RE: Comment Response Letter – Site Development Plan – Discount Tire - Falcon (File #: PPR2112)

COMMENT RESPONSE LETTER

Site Development Plan

ES.1

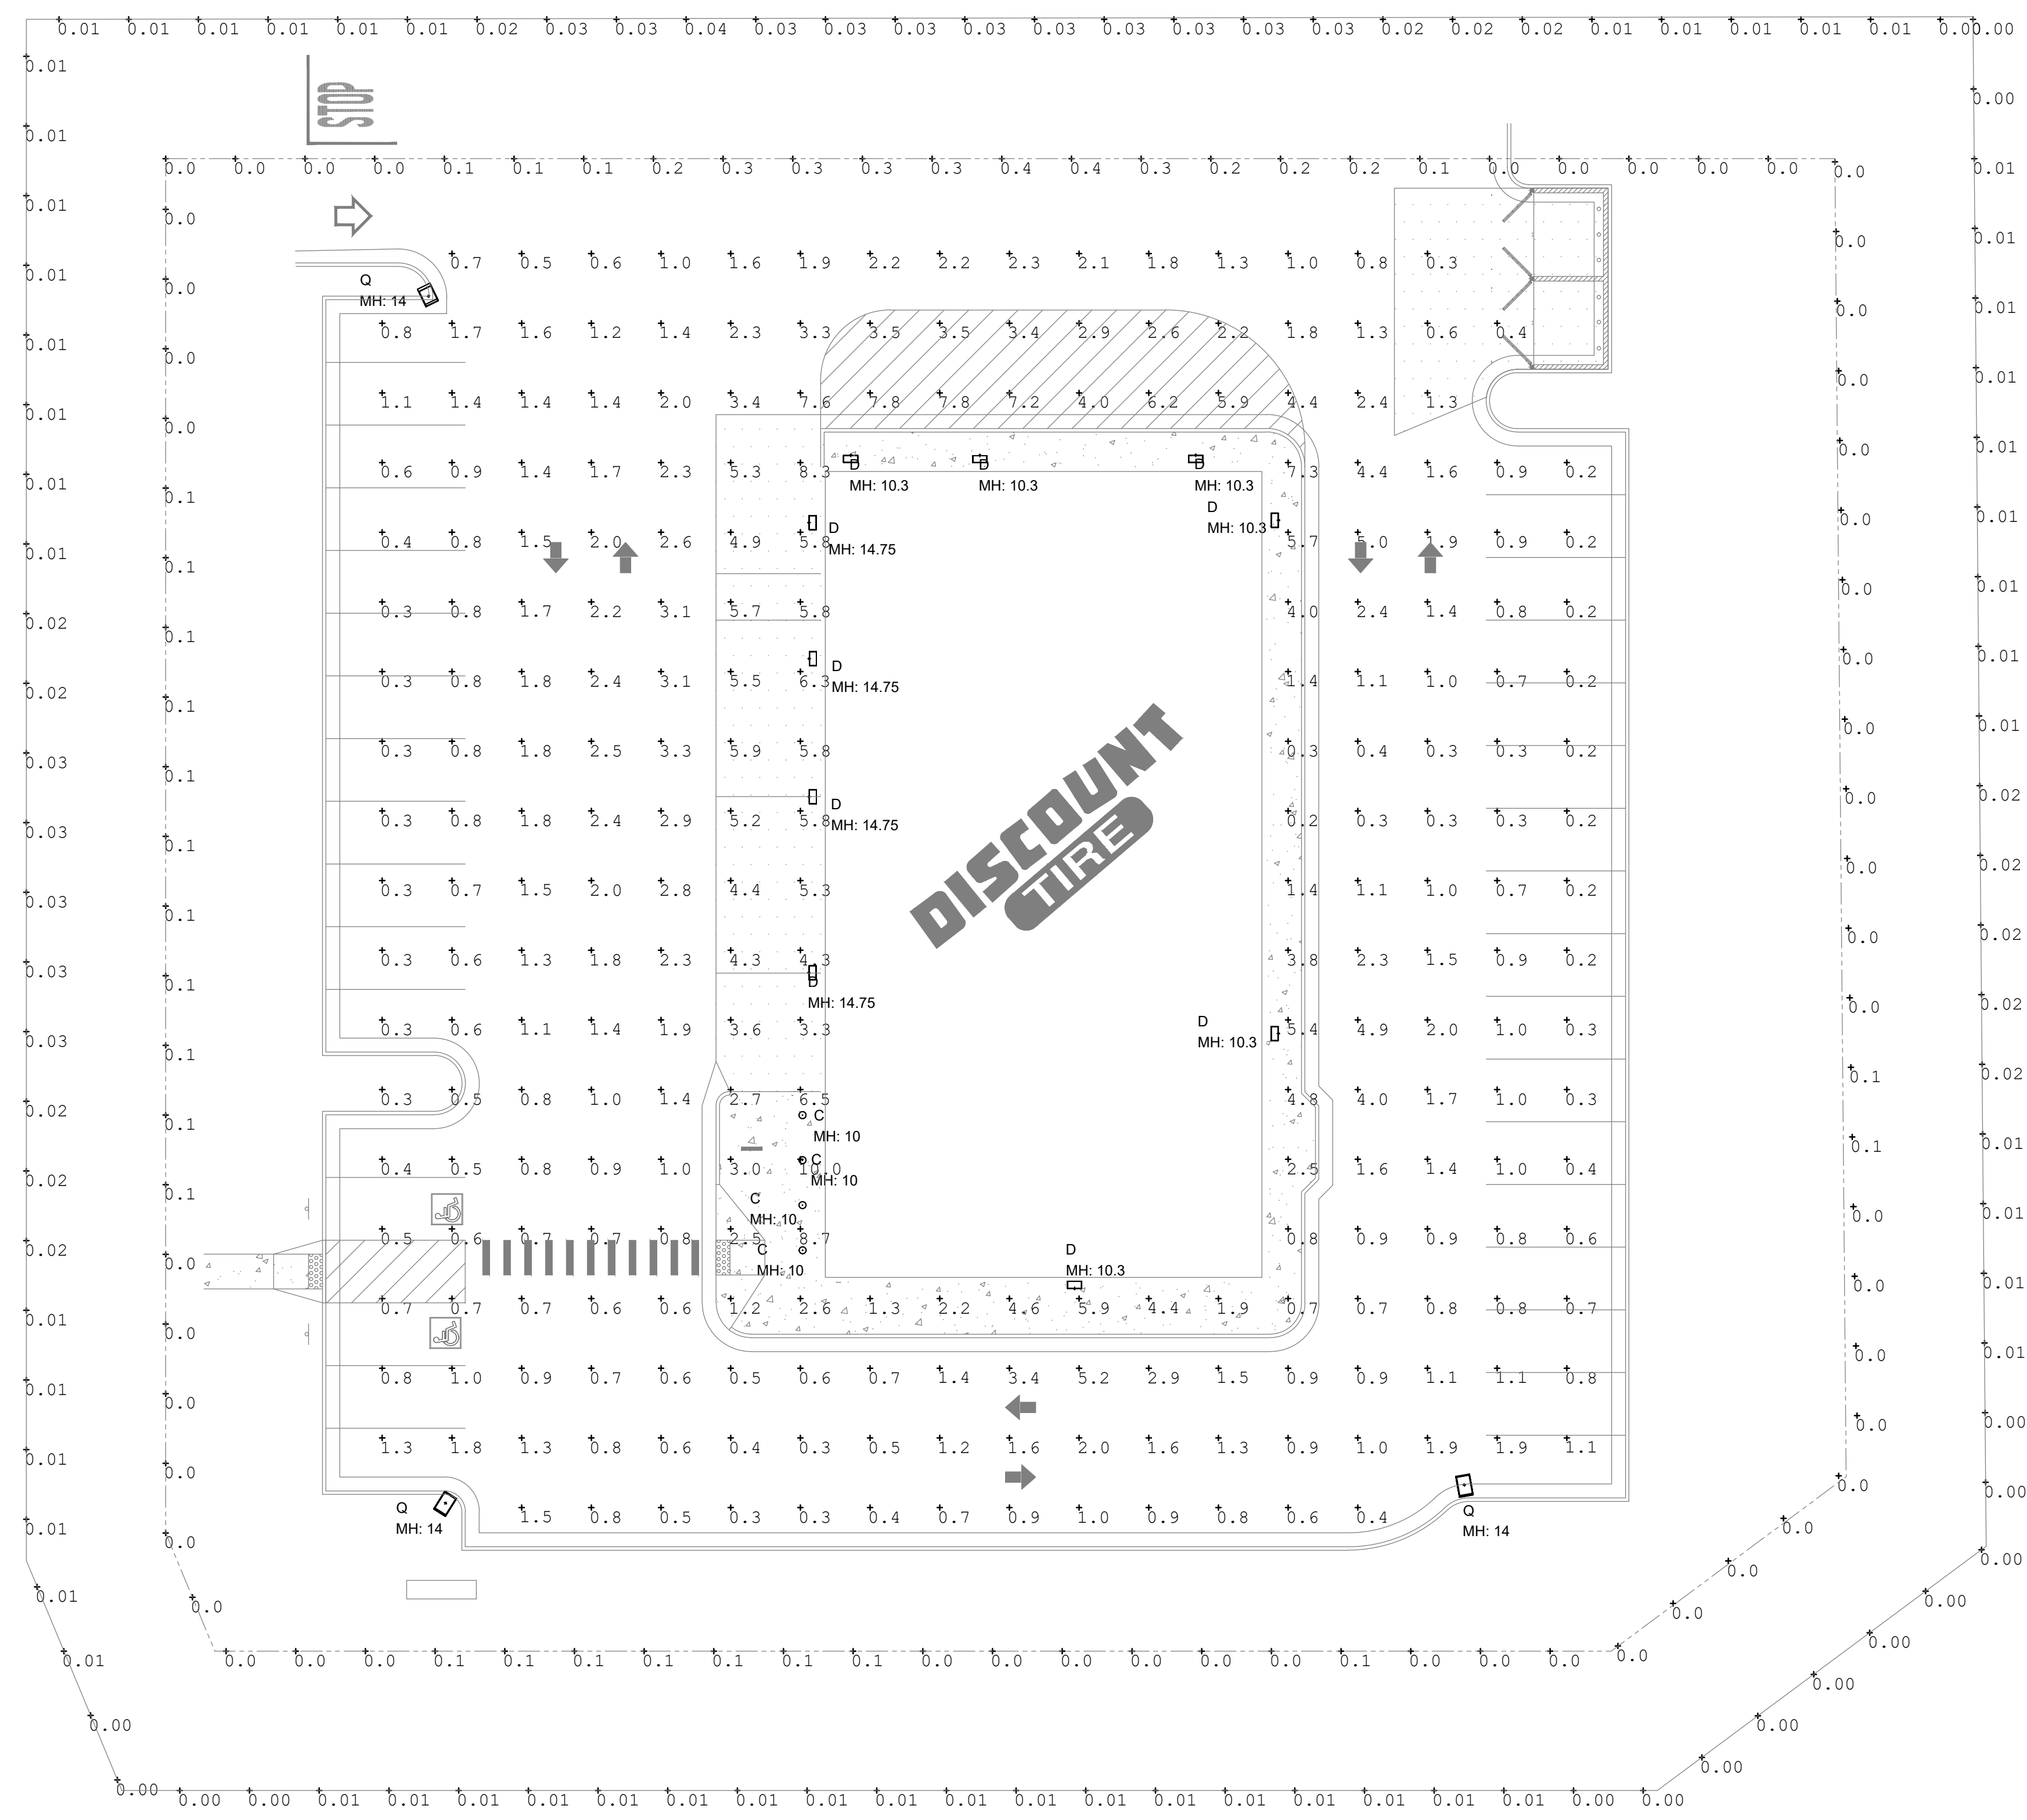
1. Include the following note related to TFX LED floodlights: Upward lighting for architectural, landscape or decorative purposes shall have at least 90% of the total distribution pattern within the profile of the illuminated structure or feature.

2. Per LDC 6.2.3(B)(1)(e), where adjacent to public right of way, lighting levels shall not exceed 0.1 foot candles.

3. Lighting can only exceed 10 foot candles on loading / unloading platforms.

- *Response: This note has been added under the section "EL PASO COUNTY LAND DEVELOPMENT CODE CRITERIA"*

- *Response: Lighting levels have been minimized to 0.1 or less at the public right of way.*

- *Response: Revised. Thank you.*
